ROBERTSON + MARKS

STAGE 1 SHEPHERDS BAY RESIDENTIAL

ACCESS REVIEW

11 December 2011

B-02,UB - 03, LG - 09, LG - 16, LG - 03, GF - 09, GF - 26, GF - 03,
1-09, 1-28, 1-03,2-09, 2-26, 2-03, 3-03, 3-21, 4-03, 4-22,

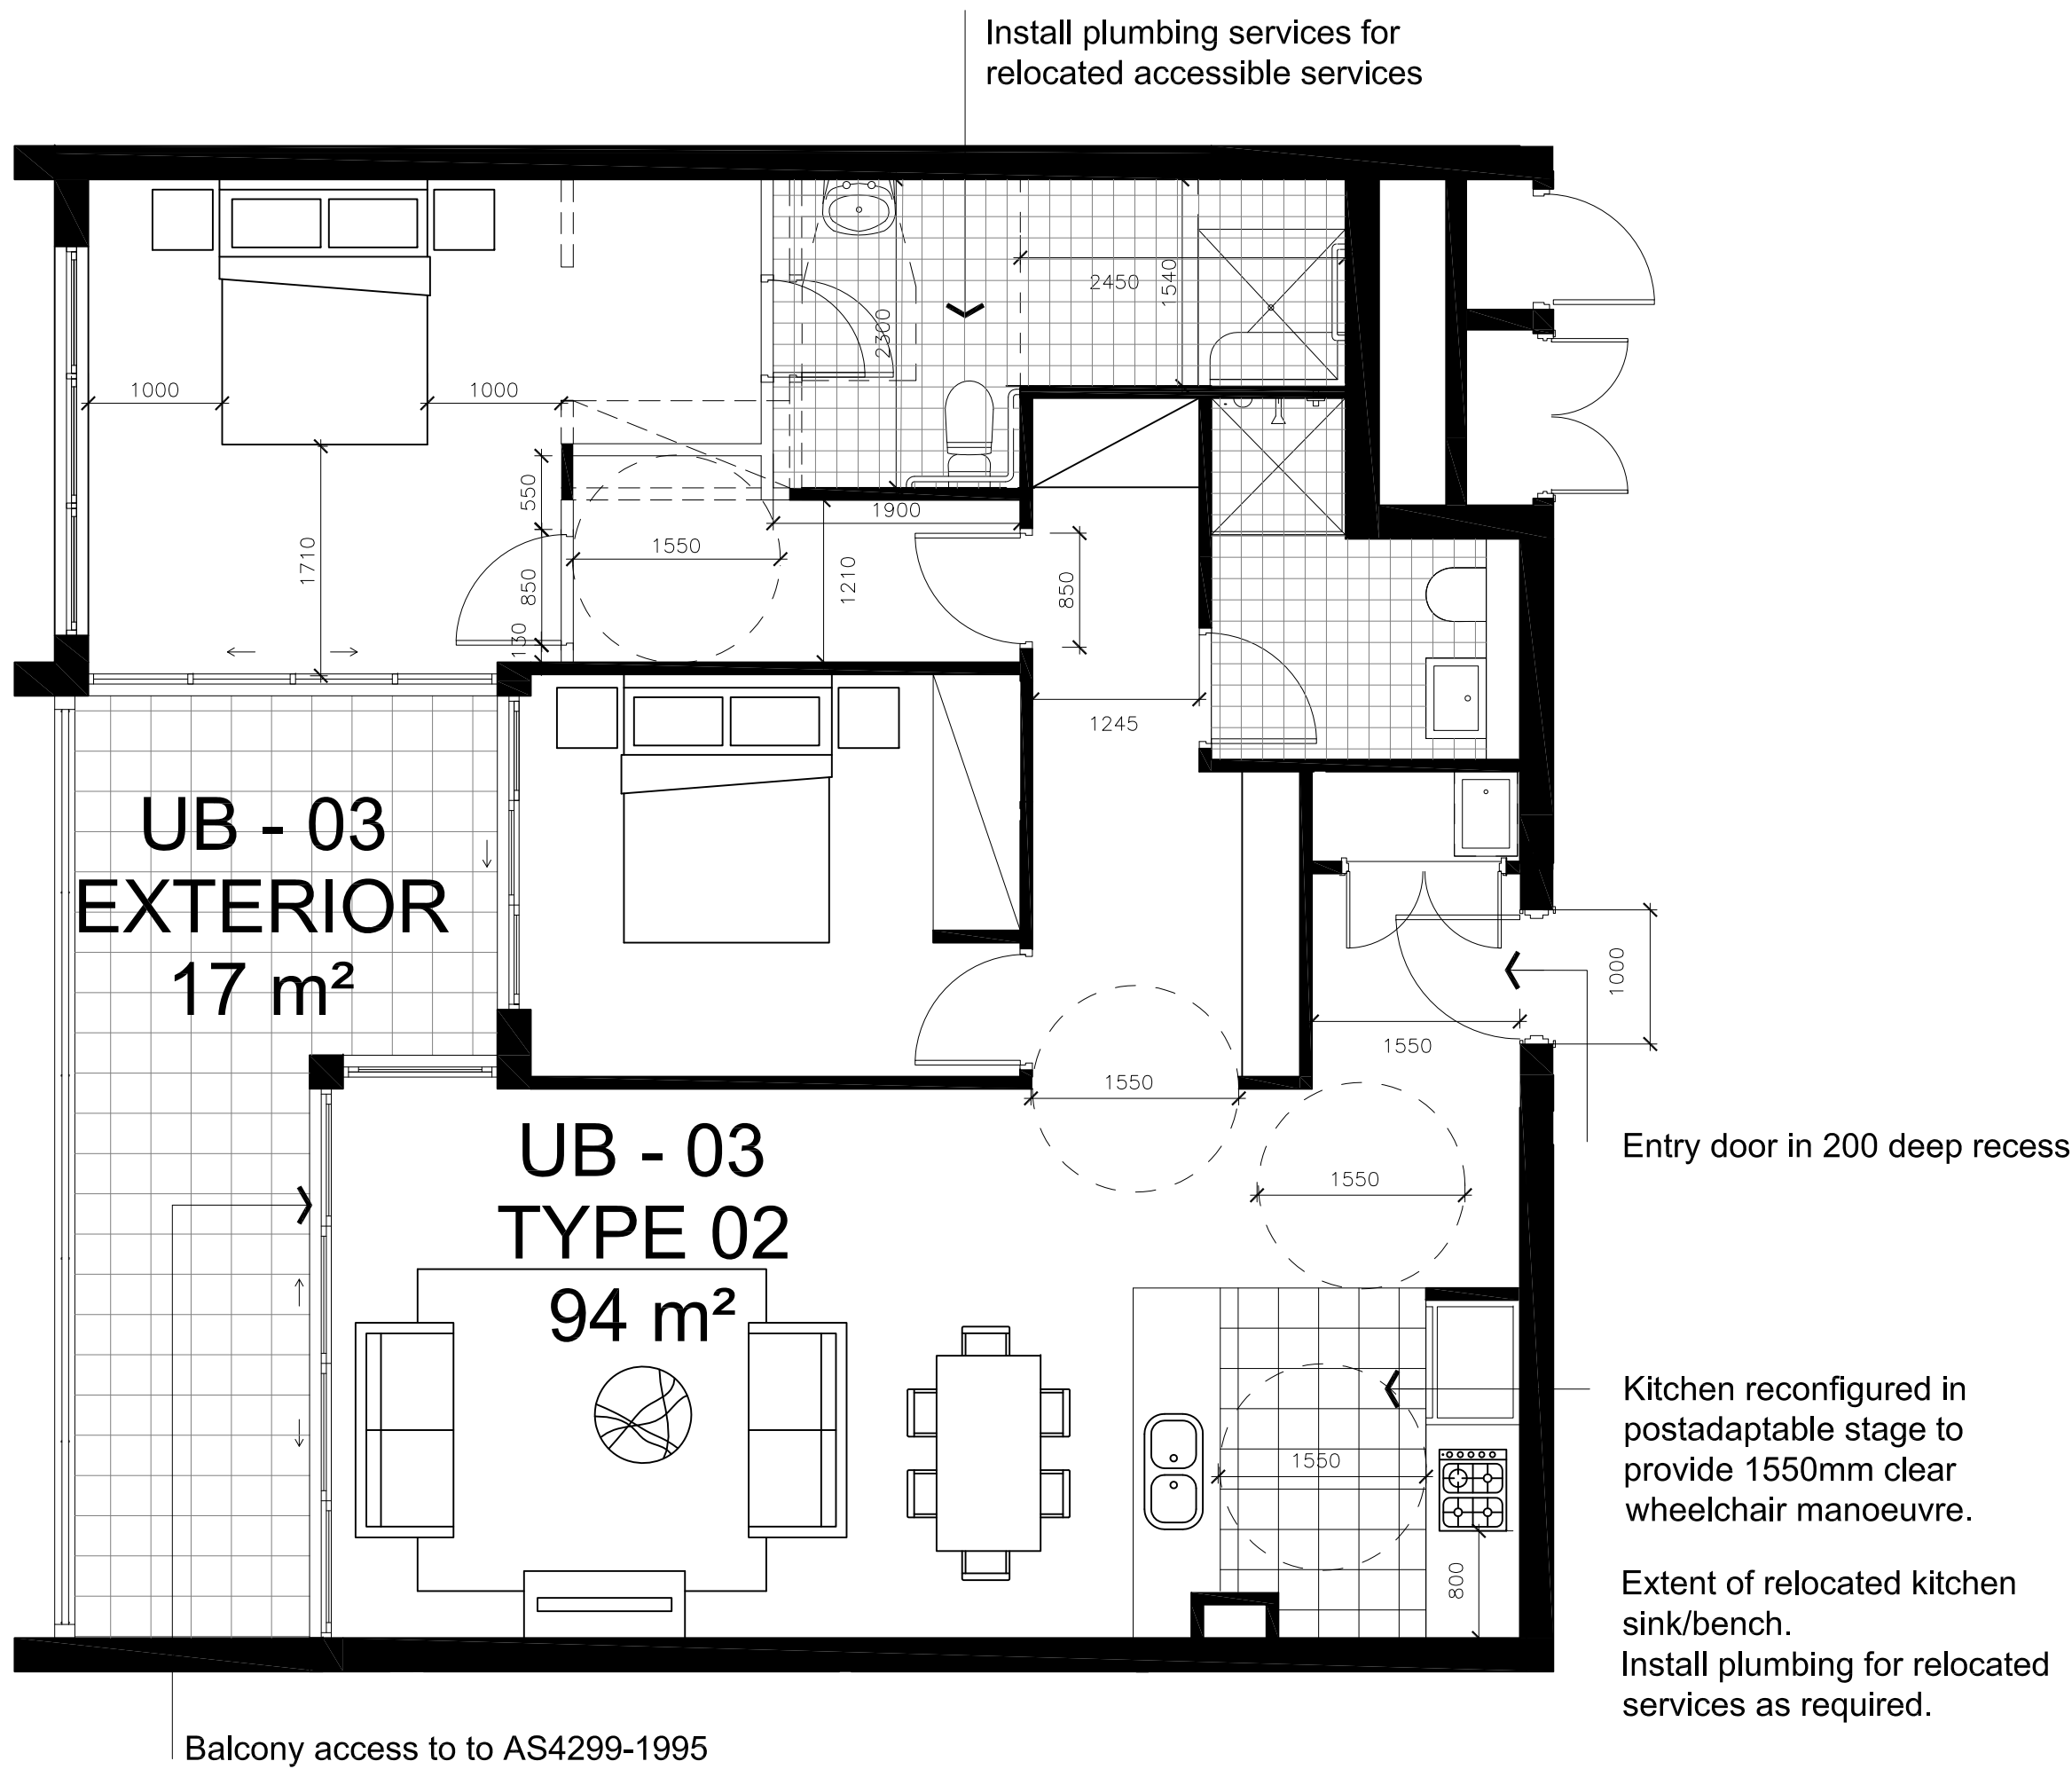
The following comments relate to units UB.03, LG.03, GF.03, 1.03, 2.03, 3.03, 4.03 and units LG.16, GF.26, 1.28, 2.26, 3.21, 4.22.

Drawings are to show post-adaptation layouts with capped off services as required in pre-adaptation drawings to achieve the circulation requirements in compliance with AS1428.1. Bathrooms are to have internal dimensions with circulation areas to cater for pan, basin and shower in accordance with AS1428.1-2009 at pre-adaptation stage. The en-suite will need to be enlarged.

There is a 1200mm clearance between base cabinets of kitchen. Drawings to show kitchen bench can be relocated to provide 1550mm clearance. Floor to be tiled pre-adaptation to allow for relocated kitchen bench. There is sufficient work bench space to allow for a compliant kitchen.

- (i) Bathroom (shower, toilet, wash basin) to comply with circulation area requirements of AS1428.1, that is provide an area of 2300mm x 1900mm around the pan. The wash basin should sit outside this area, and if needed only encroach into this area by 100mm (max). In general, the bathroom should be 2750mm x 2300mm (min).
- (ii) The kitchen is required to have a clearance of 1550mm between base cabinets (post adaptation). Provide a work bench space (800mm in length) adjacent to refrigerator, cook top, oven and sink.

PRE ADAPTABLE APARTMENTS

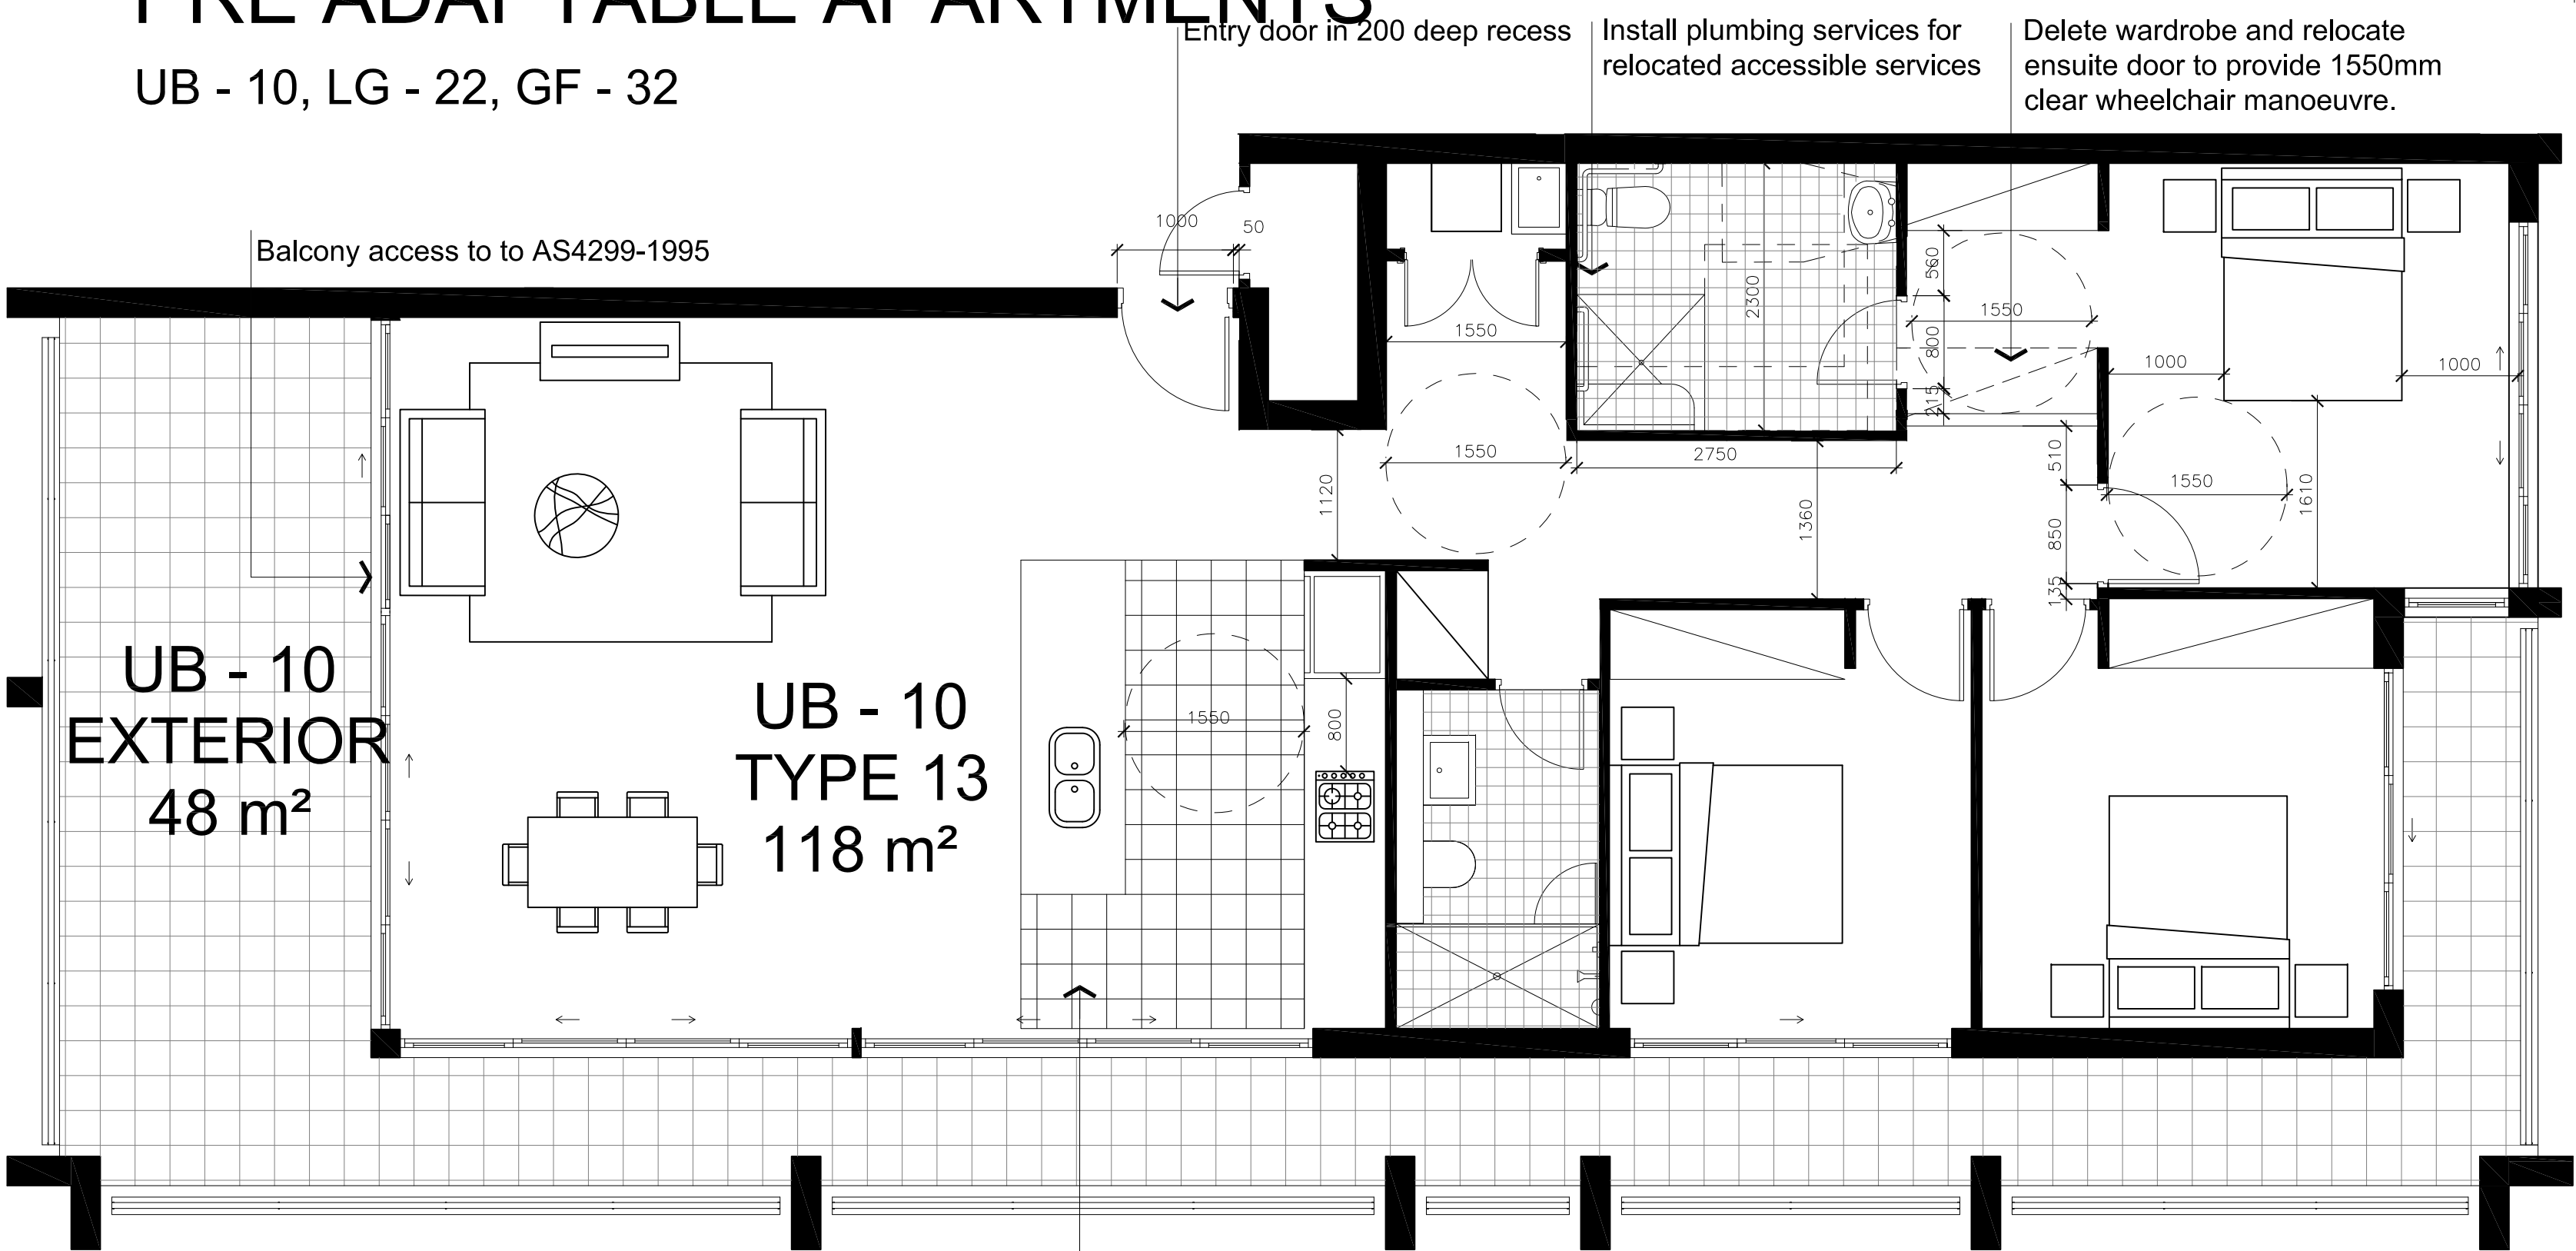
The following comments relate to unit UB.10, LG.22, GF.32, 1.34, 2.32,& 3.27.

Drawings are to show post-adaptation layouts with capped off services as required in pre-adaptation drawings to achieve the circulation requirements in compliance with AS1428.1. Bathrooms are to have internal dimensions with circulation areas to cater for pan, basin and shower in accordance with AS1428.1-2009 at pre-adaptation stage. The en-suite will need to be enlarged.

There is a 1200mm clearance between base cabinets of kitchen. Drawings to show kitchen bench can be relocated to provide 1550mm clearance. Floor to be tiled pre-adaptation to allow for relocated kitchen bench. There is sufficient work bench space to allow for a compliant kitchen.

- (i) Bathroom (shower, toilet, wash basin) to comply with circulation area requirements of AS1428.1, that is provide an area of 2300mm x 1900mm around the pan. The wash basin should sit outside this area, and if needed only encroach into this area by 100mm (max). In general, the bathroom should be 2750mm x 2300mm (min).
- (ii) The kitchen is required to have a clearance of 1550mm between base cabinets (post adaptation). Provide a work bench space (800mm in length) adjacent to refrigerator, cook top, oven and sink.
